From: Simon Davis
Sent: 27 October 2017 11:22
To: Karen Parsons
Subject: FW: BR/190/17/PL - 76 London Road, Bognor Regis

I am looking at this application and starting to write the report. First thing to note is that the s.106 has not yet been declared to be complete by our solicitor as yet so no decision can be made.

02

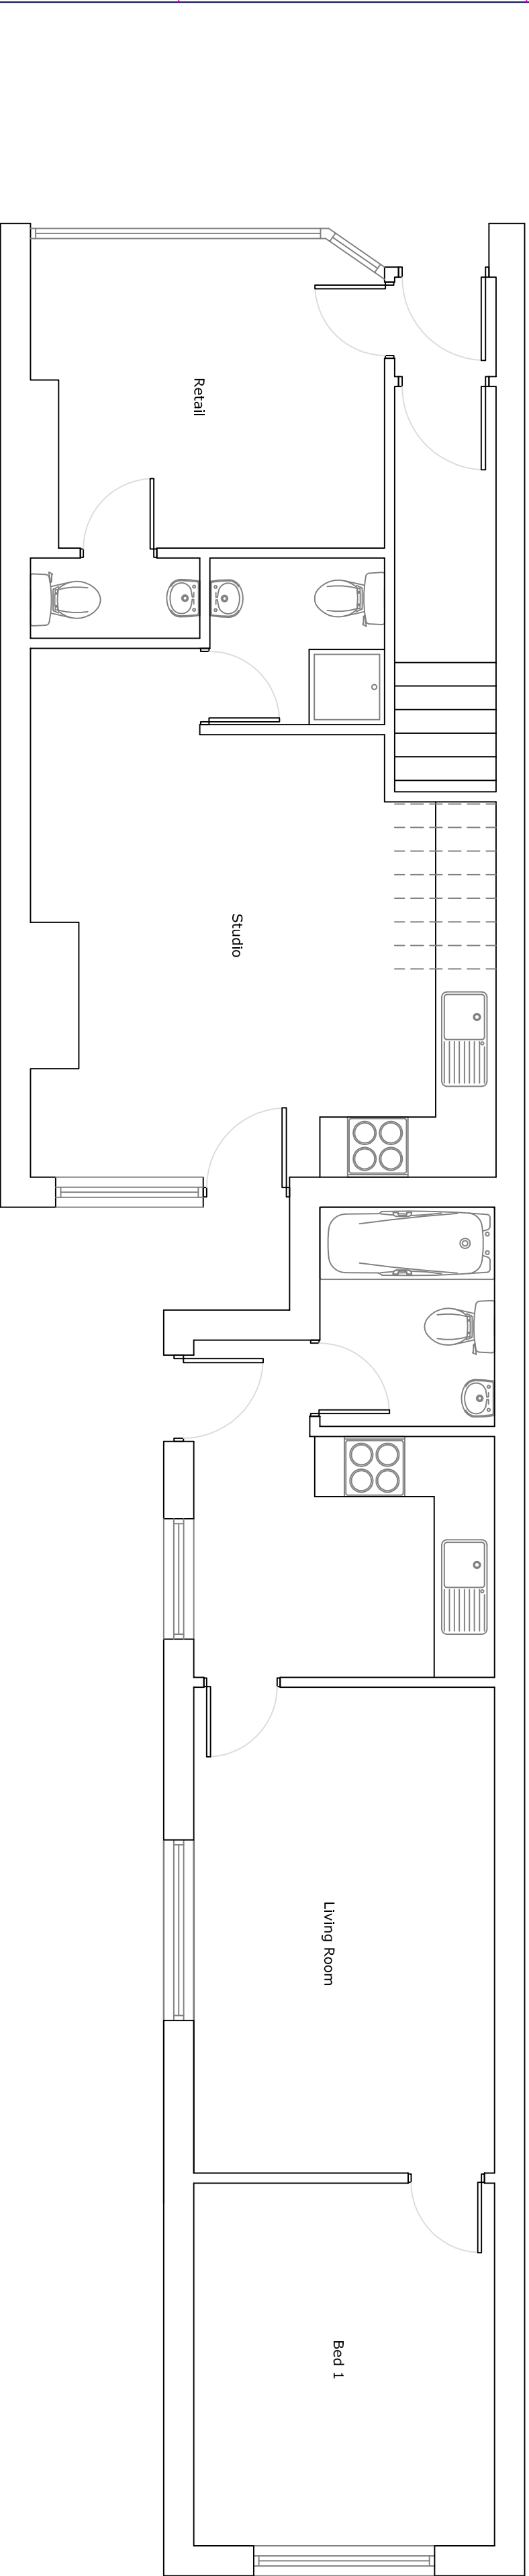
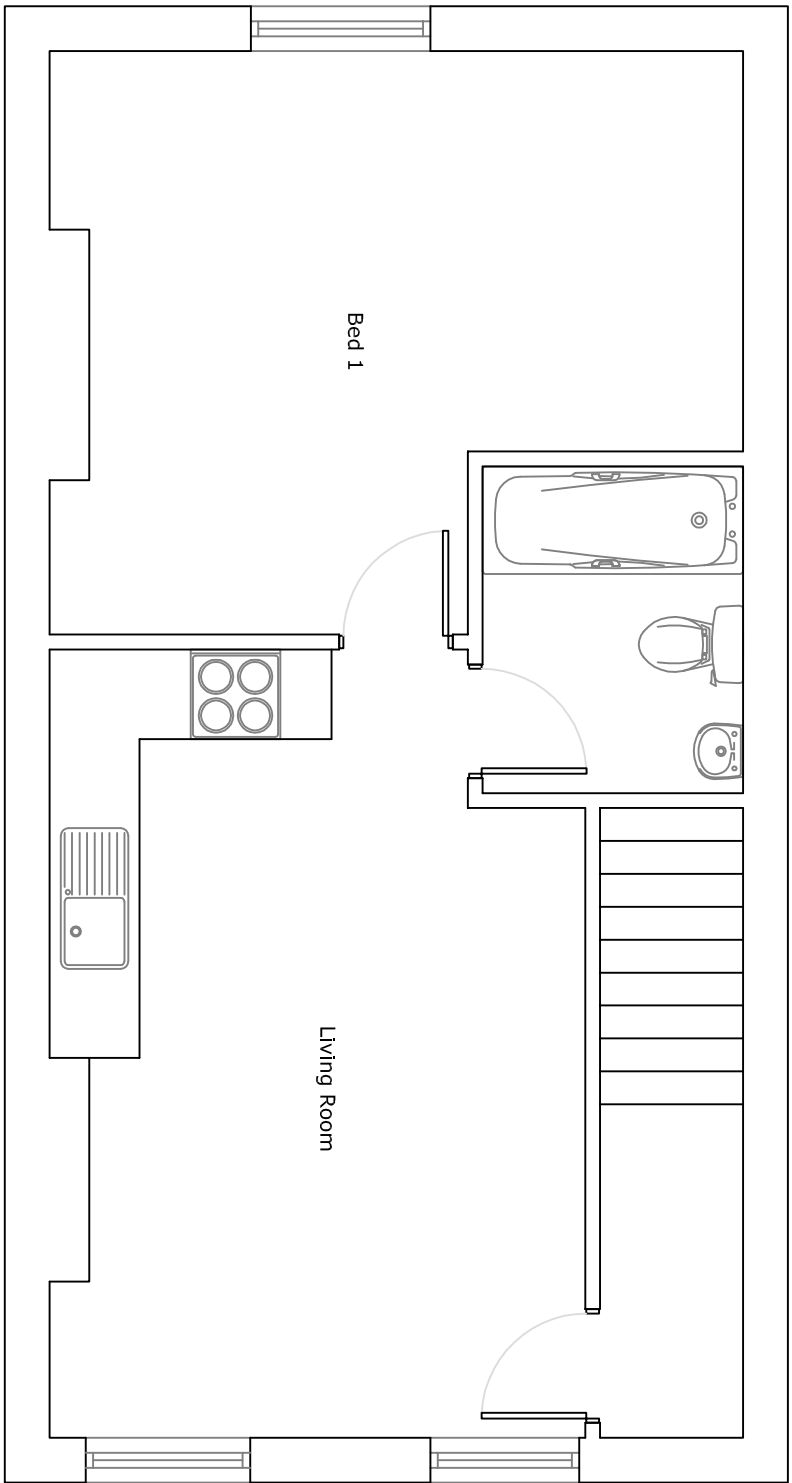
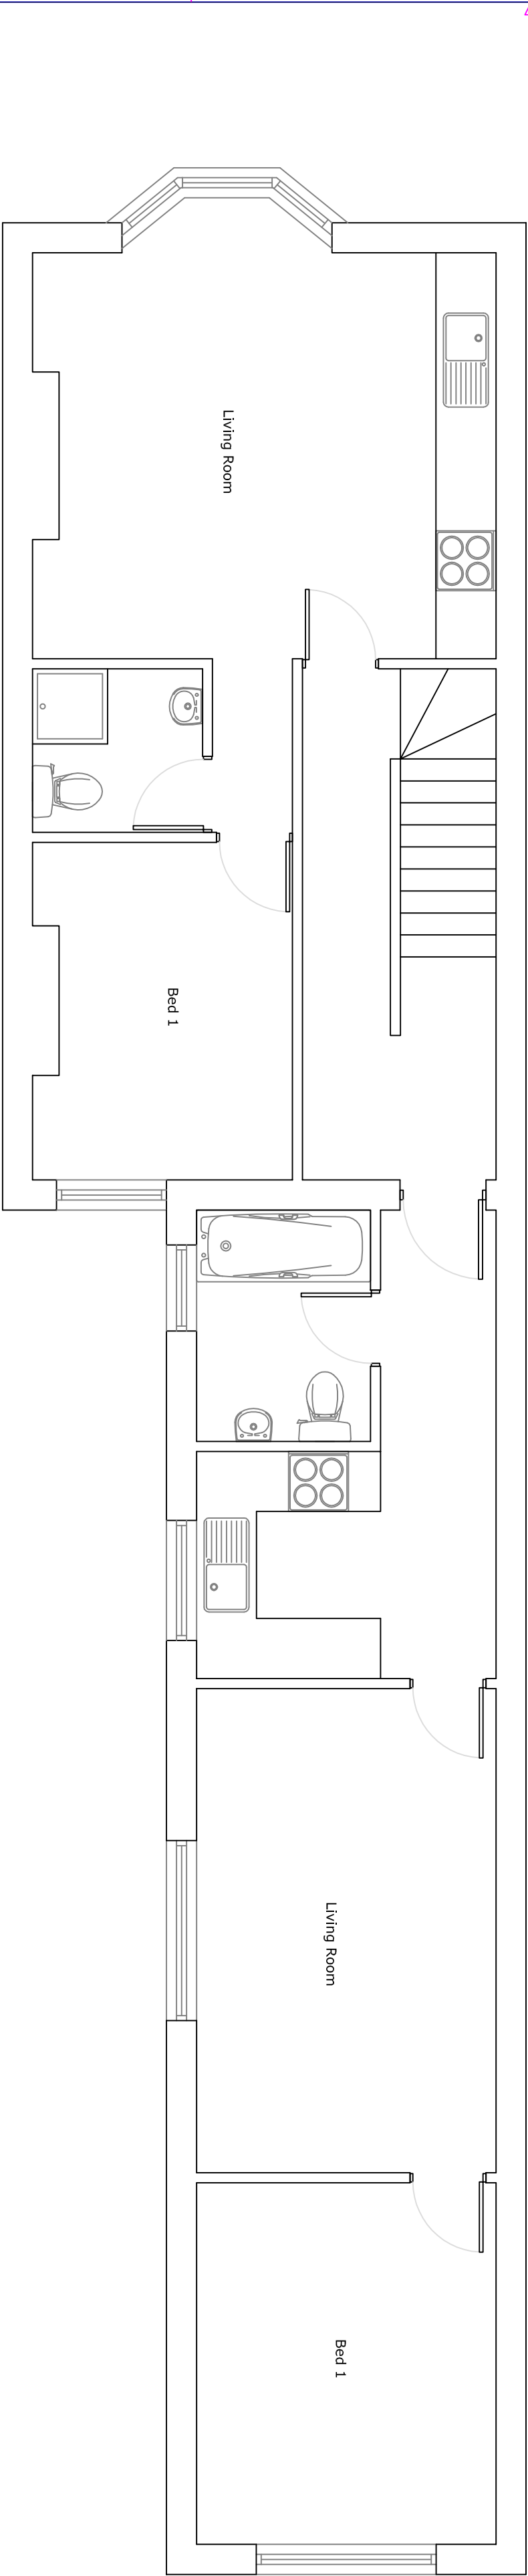
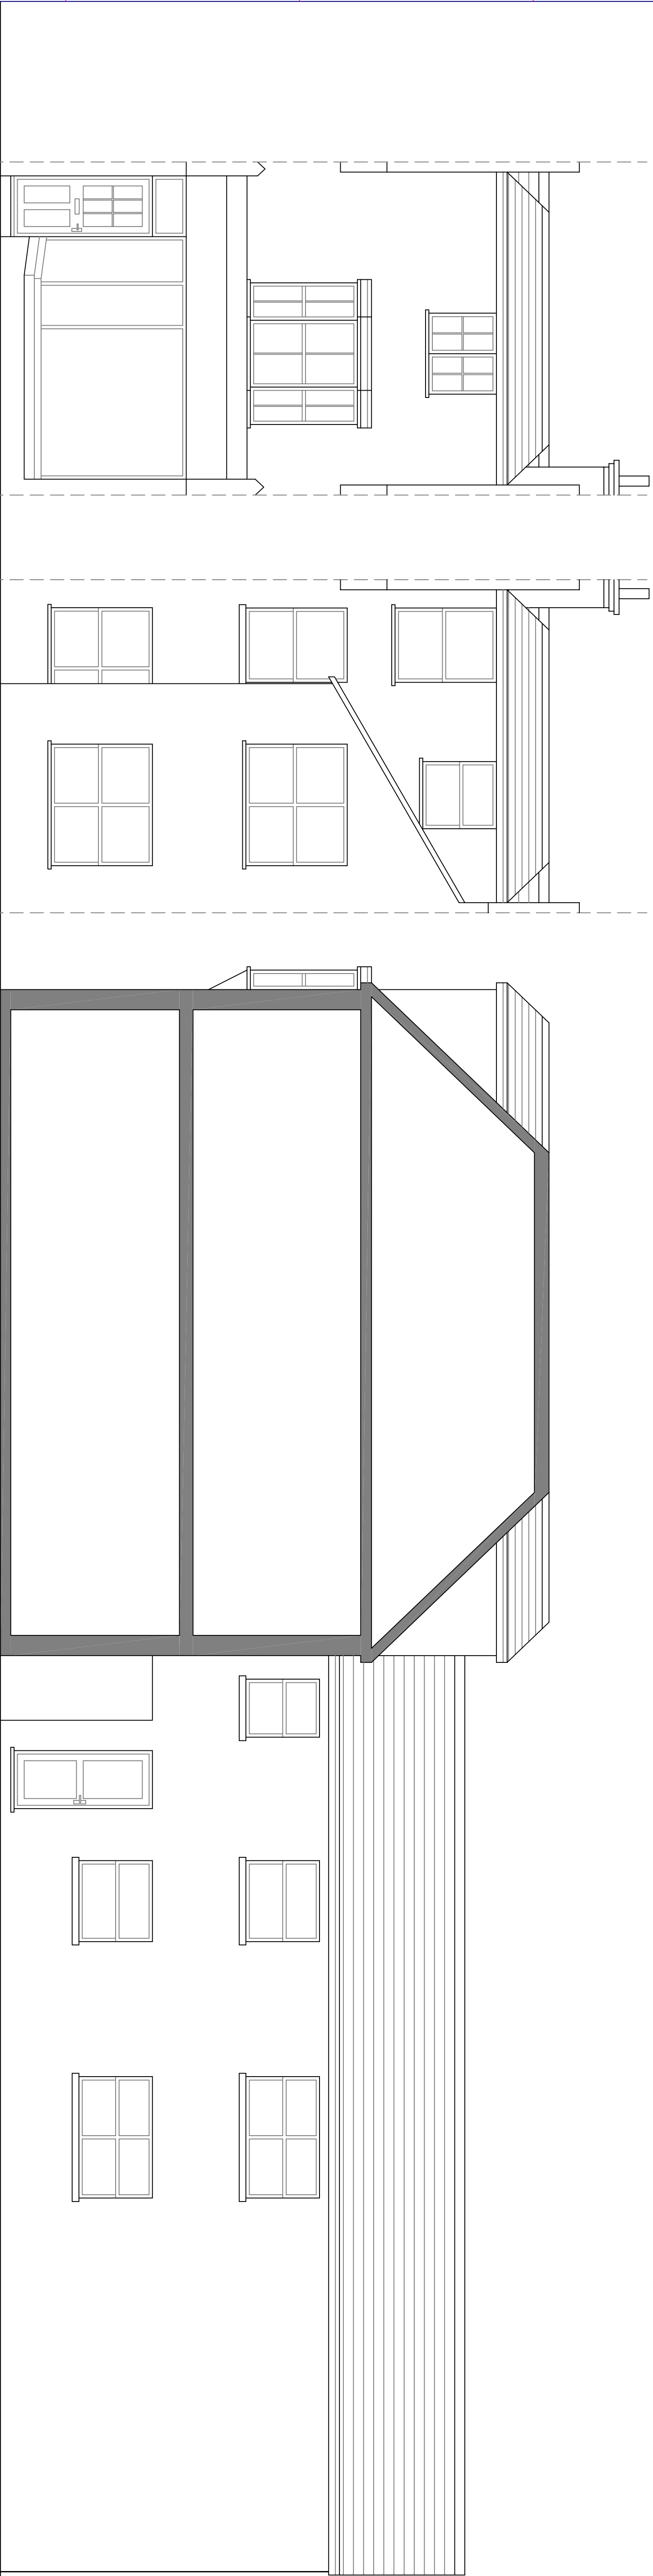
I have concerns with the amount of internal space associated with the flats. Your D&A Statement refers to compliance with the Council's emerging Local Plan policy D DM2. However, we have not been using those standards since the Government's own national standards were published in March 2015 -

The Government standards do not include a reduced space amount for studio flats and instead 1 bedroom, 1 person flats have to be 37m² (if shower room) or 39m² (if bathroom) and 1 bedroom, 2 person flats have to be 50m².

The standards state that double rooms are at least 11.5m² (so anything less is a single room). I have used this to assess your scheme:

Flat	Size	Requirement	Actual GIA	Compliance?
1	1B1P	37m ²	23.4m ²	N
2	1B1P	39m ²	37.2m ²	N
3	1B1P	37m ²	31.7m ²	N
4	1B1P	39m ²	38.8m ²	N
5	1B2P	50m ²	36.6m ²	N

Currently none of the flats comply. However, we would accept the slight (0.2m²) shortfall re flat 4. I cannot however accept the shortfall regarding the other 4 flats and this would mean a refusal

"The reduction in retail space would likely impact the viability of this unit as a retail space. There is no storage space or service area, meaning that all goods storage/food preparation etc would have to be in the same space as the sales area. Whilst many companies now operate with less stock than previously some storage space would be required."

I consider that as I have concerns with internal space standards, you could go away and look to redesign the proposal in order to (a) ensure that all flats comply with the space standards and (b) at the same time provide the retail unit with some 'back office' storage space, potentially even access to the rear yard.
